From: [Cornelis Duba](#)
To: [Thomas Piovesan](#)
Cc: [Andrew Watson](#)
Subject: NSW Planning & Environment SSD-8800 RtS for EIS Parramatta Leagues Club Hotel - Response from Endeavour Energy
Date: Tuesday, 18 January 2022 9:59:59 AM
Attachments: [image007.png](#)
[image006.png](#)

I refer to the Department's below email of 17 January 2022 regarding the Response to Submissions (RtS) for the Environmental Impact Statement (EIS) for State Significant Development SSD-8800 Parramatta Leagues Club Hotel at 1 Eels Place, Parramatta [Lot 369 DP 752058, Lot 7054 DP 1074335 & Residual Crown Plan 80-3000 (Sydney)] for 'Construction of a 17 storey hotel comprising 209 hotel rooms, one basement level for services, ancillary uses including a pool, gym, cafe, bars and function room, vehicular access from O Connell Street, public domain works and tree removal'. Submissions need to be made to the Department by 7 February 2022.

DRAWING TITLE
GA FLOOR PLAN - LEVEL B01 (BASEMENT) - PLANT & HOTEL BOH

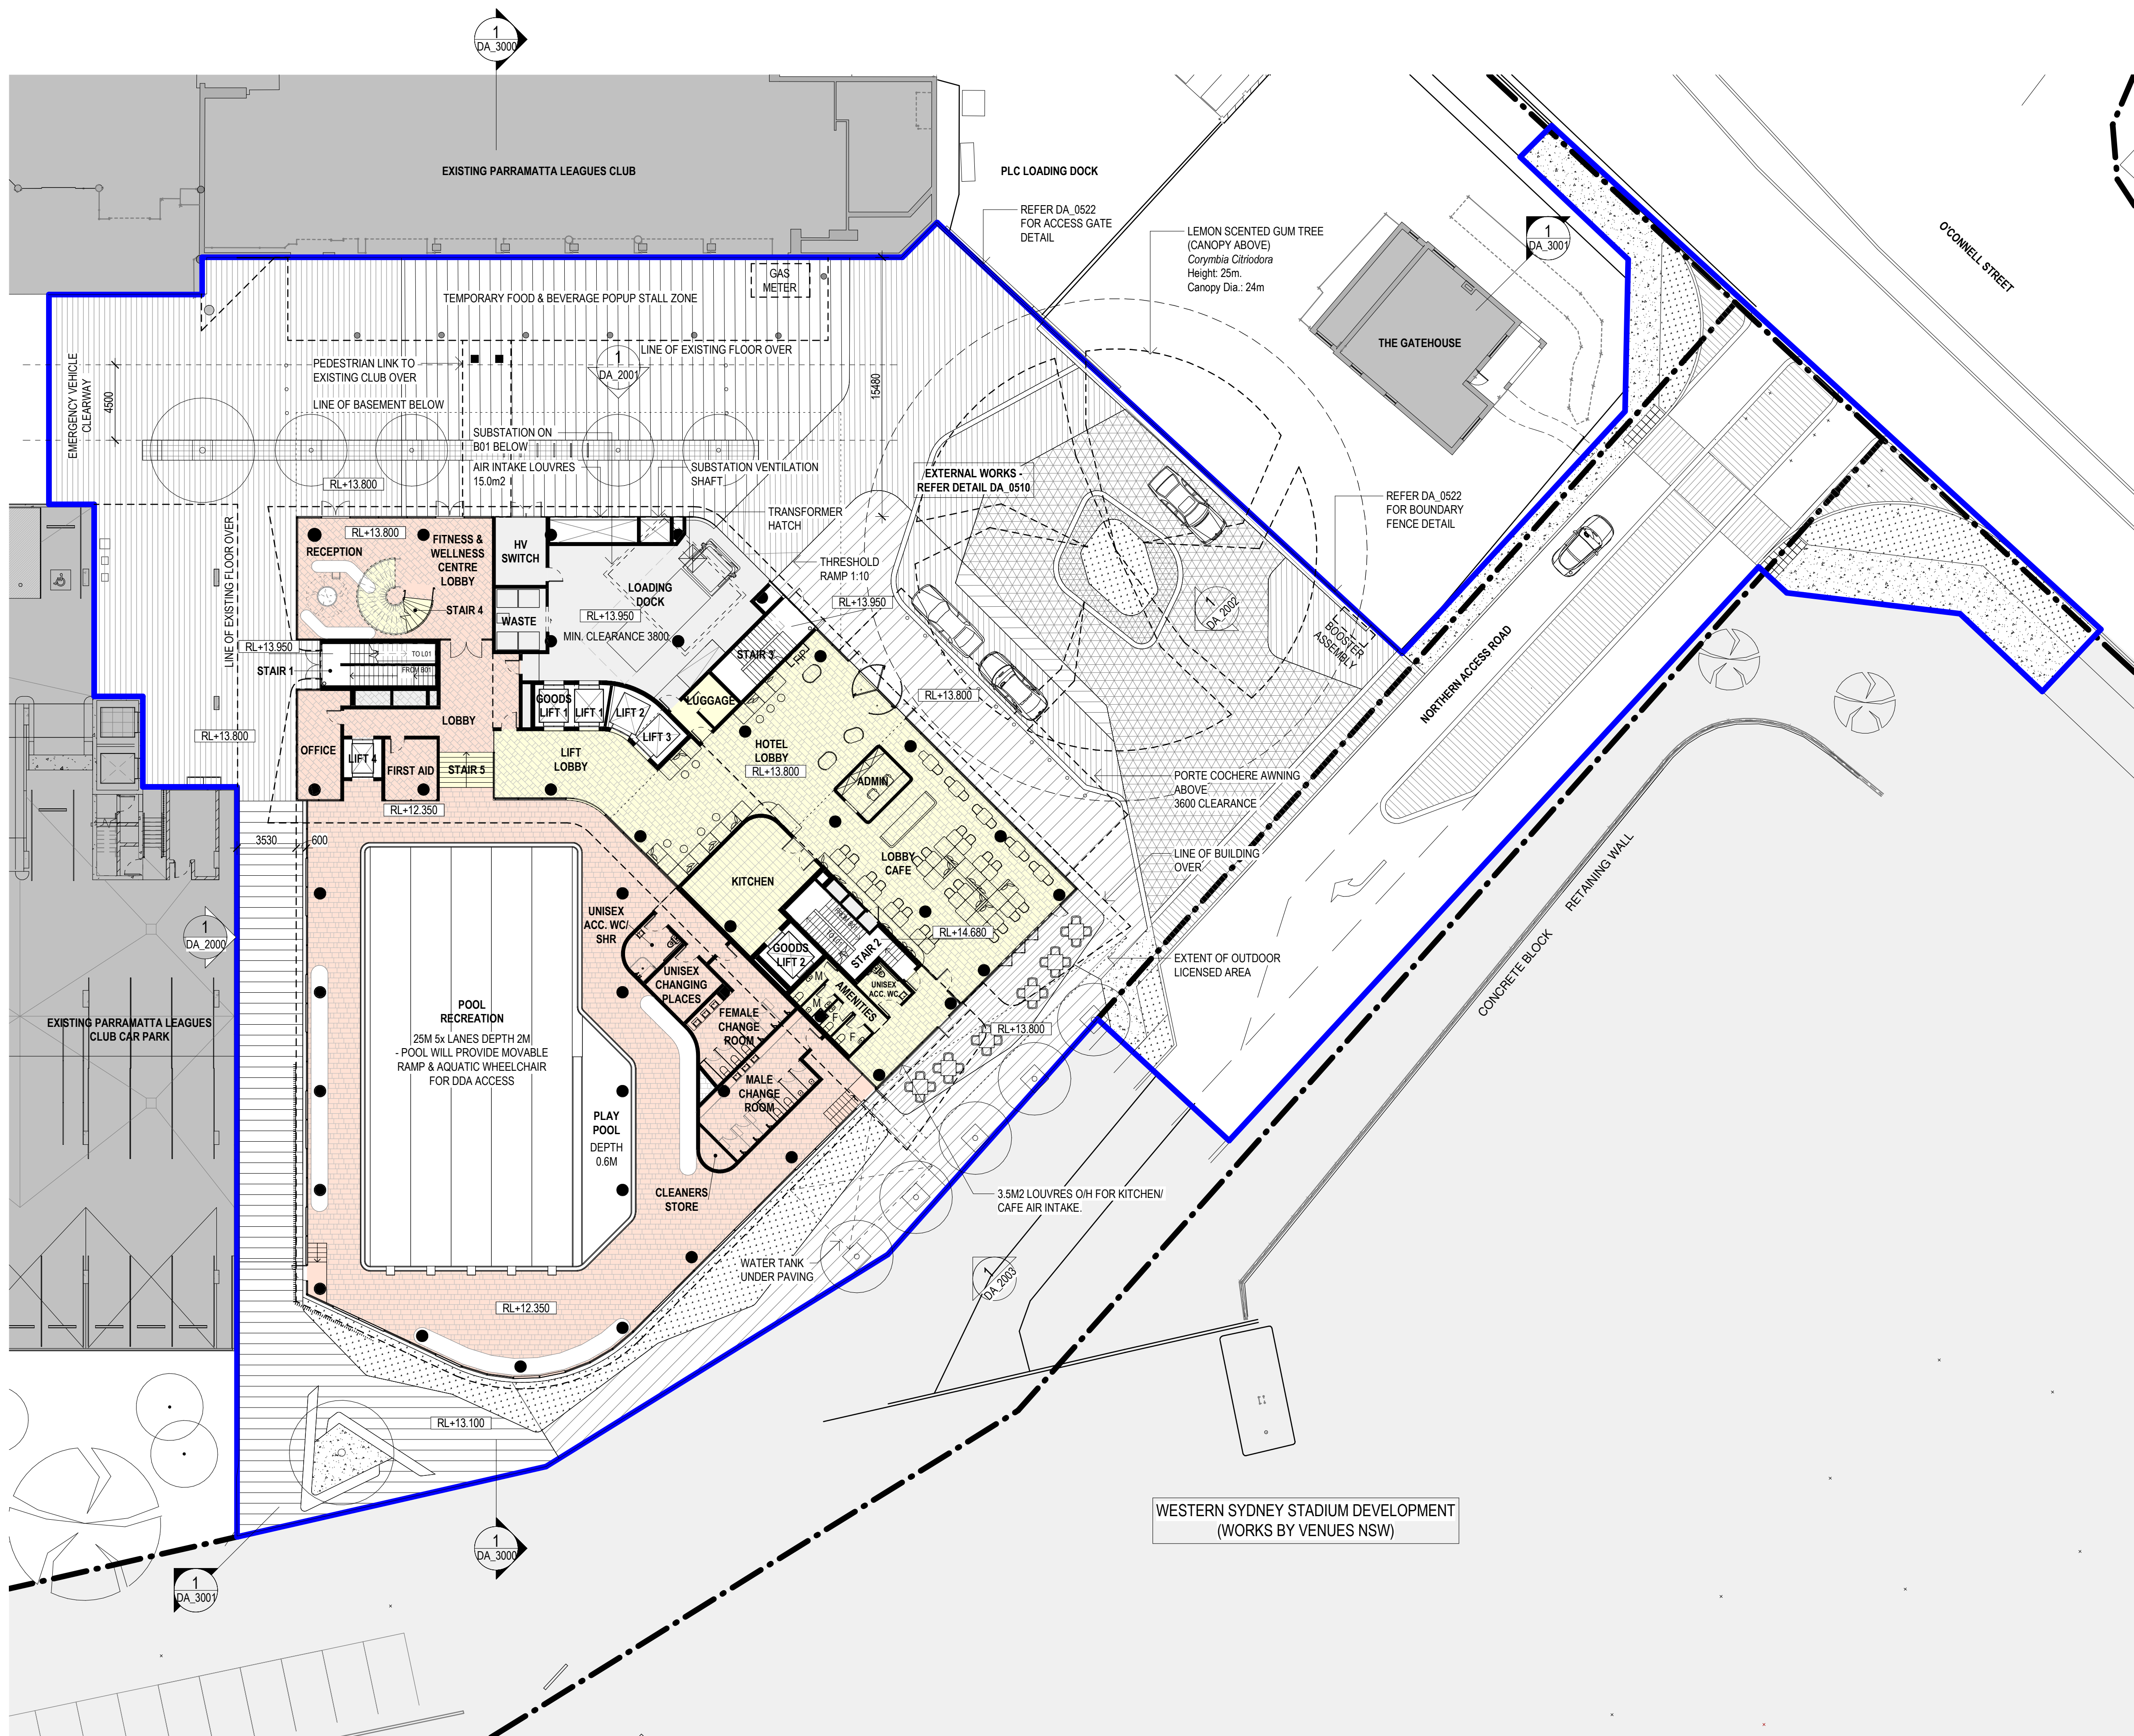
The following extracts of the updated Architectural Drawings show the proposed indoor substation has been relocated but remains in the basement.

The RtS acknowledges Endeavour Energy's submission made to the Department on 21 February 2019 for the EIS but does not appear to provide any further advice / update regarding the provision of electricity supply to the proposed development. Accordingly the recommendations and comments provided in Endeavour Energy's submission for the EIS remain valid.

Distribution substations should not be subject to flood inundation or stormwater runoff. Section 7 'Substation and switching stations' of Endeavour Energy's Mains Construction Instruction MCI 0006 'Underground distribution construction standards manual' provides the following details of the requirements for flooding and drainage in new distribution substation locations.

Substations are to be located such that the risk of flooding or stormwater damage is minimal.

As a minimum the level at the top of the transformer footing, HV and LV switchgear, shall not be lower than the 1:100 year flood level.

In areas where, as determined by the Network Substation Manager, there is a high water table or a heightened risk of flooding, indoor substations will not be permitted.

All materials used in the construction below the substation (ground level) shall be capable of withstanding prolonged immersion in water without swelling or deterioration.
